**Re: Planning application 2023/62/91116/E**

**Erection of 77 dwellings, with access from Darley Road and associated works at Land off Primrose Lane, Hightown, Liversedge – FURTHER RECONSULTATION**

**The Coal Authority response: MATERIAL CONSIDERATION**

PROJECT	LAND OFF PRIMROSE LANE, LIVERSEDGE			
DRAWING TITLE	MINE SHAFT ZONE OF INFLUENCE DRAWING			
DRG No.	LD11032-001	REV	P02	SUFT. CODE
DRG SIZE	A1	SCALE	1:500	DATE
DRAWN BY	MC	CHECKED BY	JC	APPROVED BY
				22.07.24

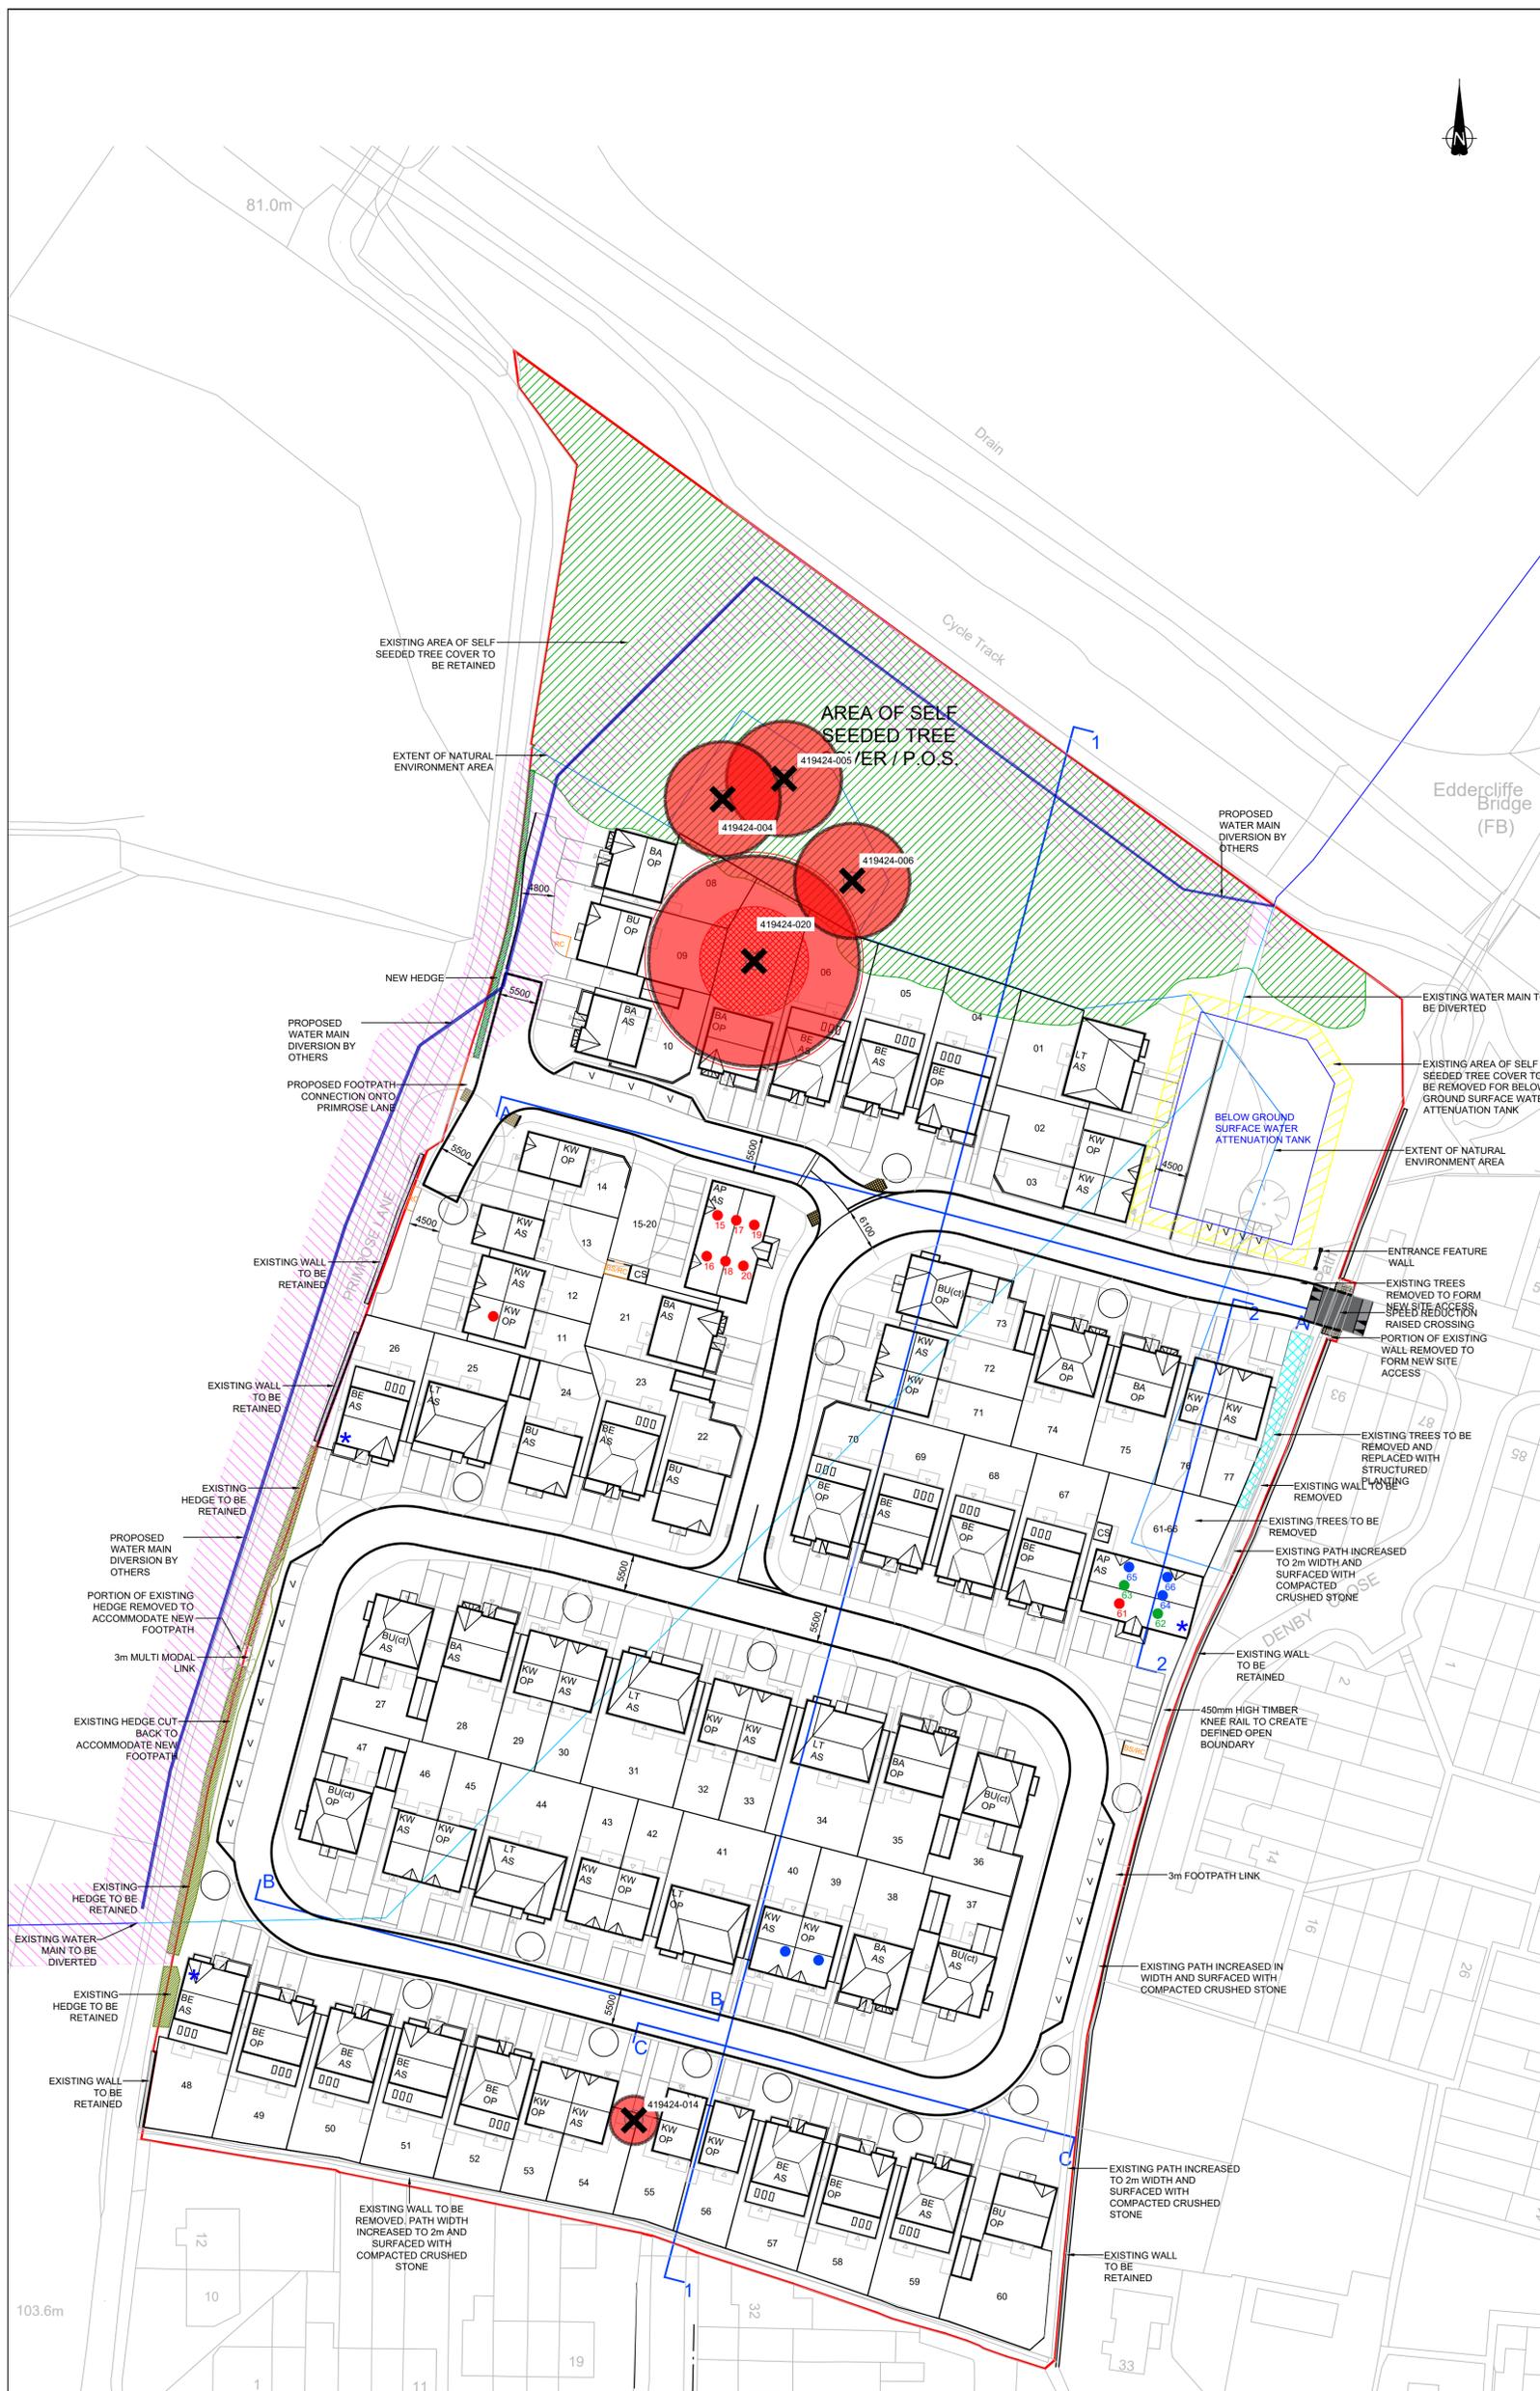
proposed layout of development had been suitably informed by the mine shafts and their associated zones of influence recorded to be present within the site. We were particular concerned with shaft 419424-020 which could result in built development at Plots 6, 7 and 10 being sited within the zone of influence of this shaft.

The note confirms that further consideration has been given to the presence of these shafts through revisions to the alignment of the proposed diversion of the Yorkshire Water main, which will now run adjacent to the north eastern site boundary. However, it is evident from the detail shown on the Mine Shaft Zone Drawing that proposed built development at Plots 6, 7 and 10 remain within the potential zone of influence of shaft 419424-020.

positions does not include all of their associated potential zones of influence (as shown on the Mine Shaft Zone of Influence Drawing appended to the Technical Note).

As communicated to the applicant's technical consultants, the Coal Authority's Planning & Development Team is satisfied that our objection to the layout of the proposed development may be overcome by the imposition of a suitably worded condition effectively reserving the detail of built development at Plots 6, 7 and 10, along the lines of that proposed by Wardell Armstrong. We highlighted that this would of course be subject to the LPA being amenable to this approach.

On the basis of the information reviewed, the Coal Authority's Planning & Development Team would be able to **WITHDRAW ITS OBJECTION** to this application subject to the imposition of conditions on any permission issued to secure the following:

- ***The reserving of approval of the detail of built development at Plots 6, 7 and 10, as suggested by Wardell Armstrong.***
